77 Aldwick Road
Bognor Regis
West Sussex
PO21 2NW

Your Ref: BR/63/18/PL

13 June 2018

Comments on LPA's position in respect of the application for residential development at 77 Aldwick Road, Bognor Regis, PO21 2NW (application ref: BR/63/18/PL)

EXISTING & PROPOSED
ELEVATIONS

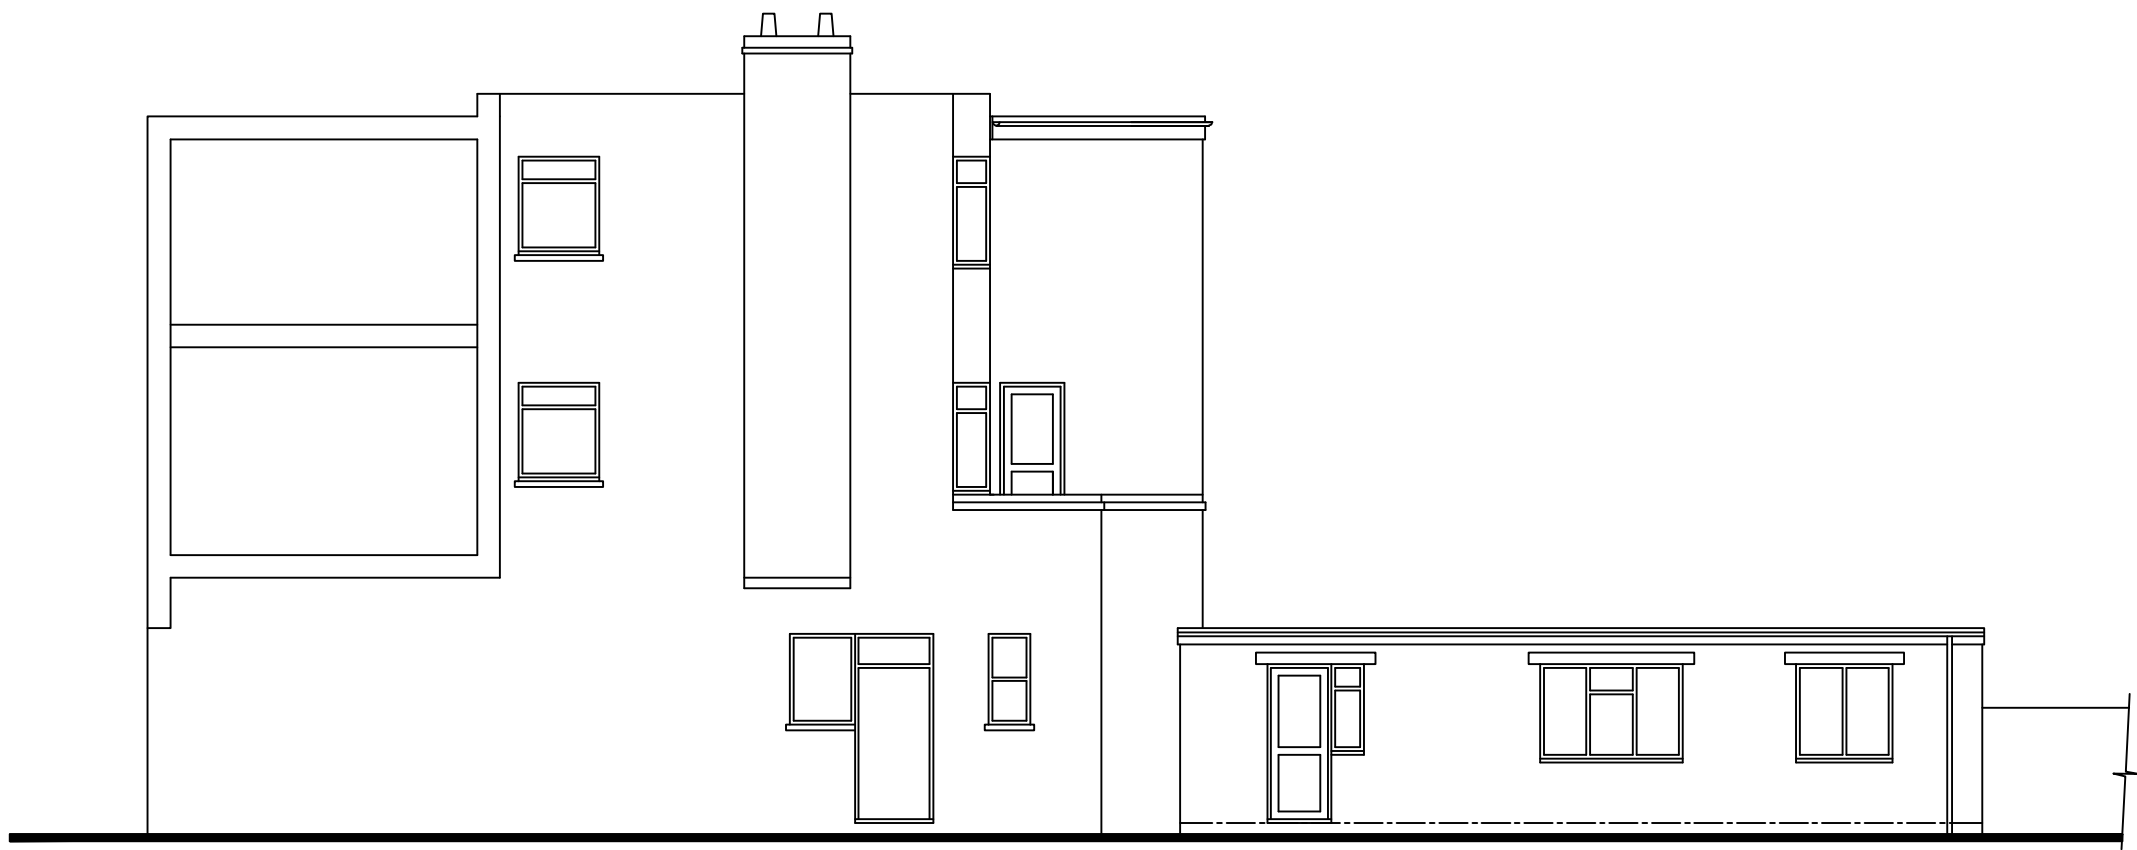
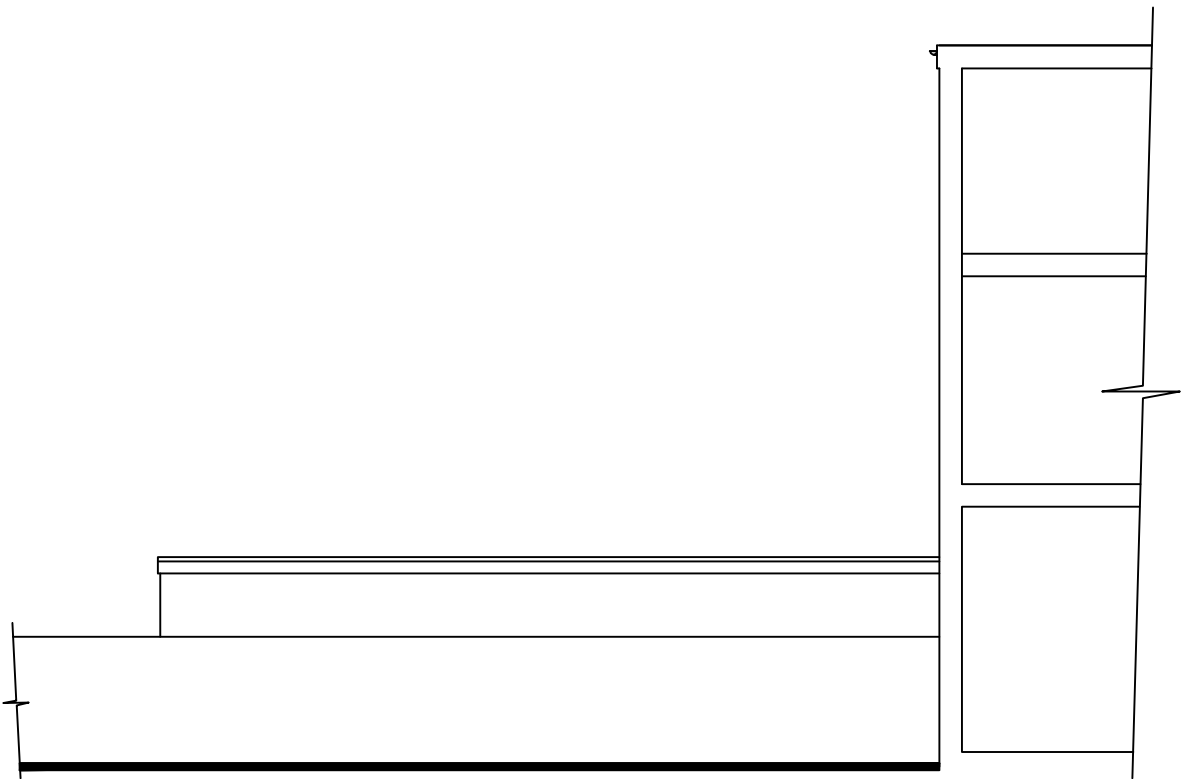
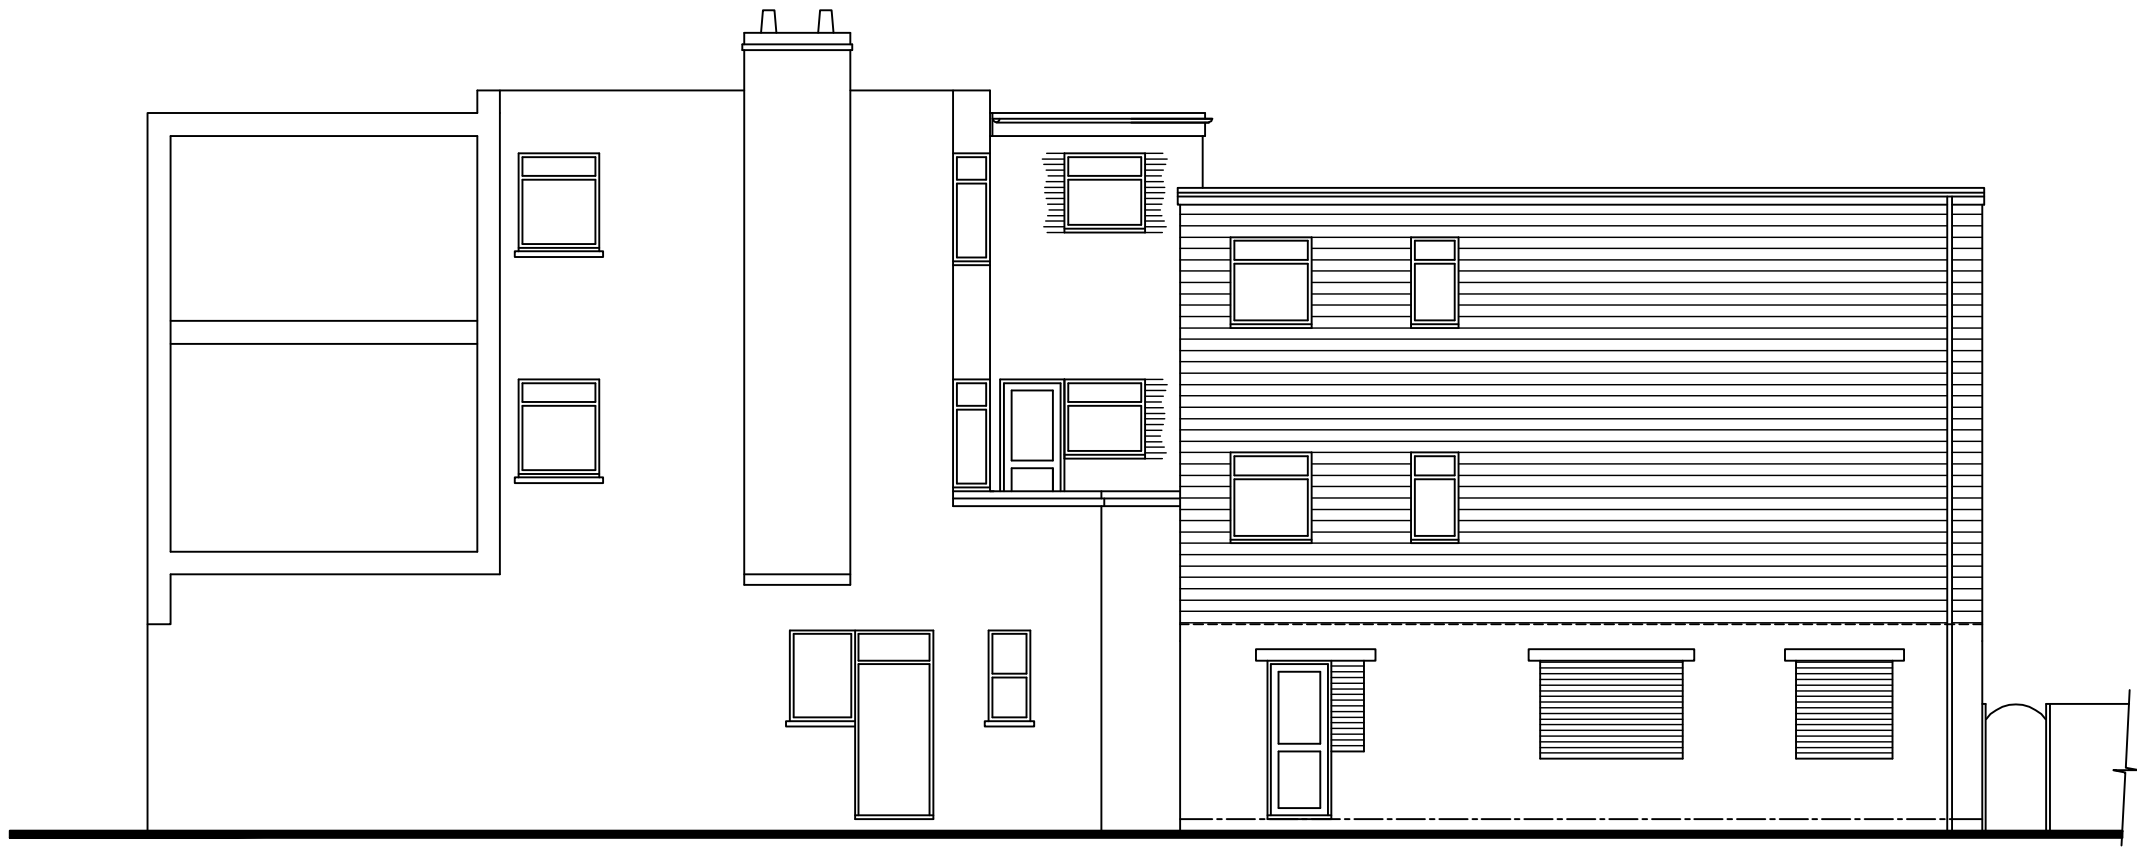
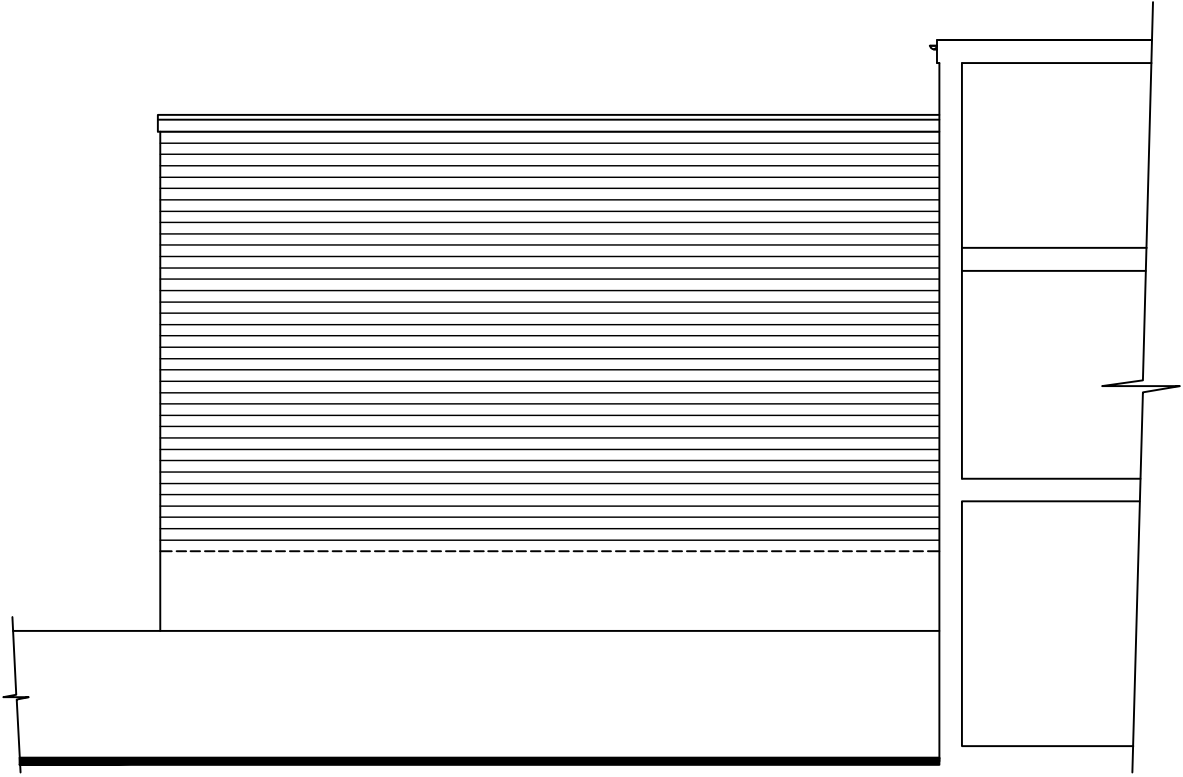
The first and second floors feature a small bedroom window positioned approximately 3m from the boundary line with the application site. The proposed extension may infringe marginally on the amount of daylight and late afternoon sunlight afforded to the first floor bedroom, however such an impact is minimal in the context of the application as a whole.

The head of the second floor window on no.75 sits above the roofline of the proposed development, and so there will be no impact on sunlight or daylight above the existing skyline to this window. Any perceived concerns of a loss of daylight or sunlight are simply not sustainable in this instance.

You will note that the first floor fire escape and terrace area on the rear of no.75 are set a considerable distance from the eastern flank wall of the development, thereby remaining unaffected in terms of daylight and sunlight in this respect.

Essentially therefore, as a matter of fact, the LPA is relying on a case of harm based on a marginal loss of daylight and sunlight to one bedroom window on the first floor of the rear elevation of no.75. There are no other windows or outside amenity areas that would fail to meet the BRE daylight and sunlight guidance, and this can be evidenced in any appeal against the refusal of permission.

Any impact on daylight and sunlight to openings (b), (c) and (e) are not material as the rooms that are served are not considered to be habitable in terms of the BRE guidance. The development would not fail the BRE test in respect of opening (a) as there will be no discernible impact on daylight and sunlight above the existing baseline conditions. This is because opening (a) already faces directly onto a three storey building and is enclosed in this respect. Opening (d) is given very limited weight as it is a secondary window opening only, and there is a substantial opening in the rear elevation of the room served, from which it currently and will receive more than adequate daylight and sunlight.

For the same reason as the second floor bedroom window in no.75 would not be affected, window (g) would also not be adversely affected, as the head of this window and its top half would sit above the roof of the proposed development.

This leaves opening (f), which is a first floor south facing window used for habitable purposes. The window is set-off the boundary with the application site by approximately 2.0m and provides a large glazed area of some 2.7m in width. The proposed development will conflict with the 45 degree angle of daylight to this window, however as the extension will only be approximately 1.5m greater in height than the affected window, any loss of daylight or sunlight will be marginal and certainly not a significant impact. No objections have been raised by this neighbour.
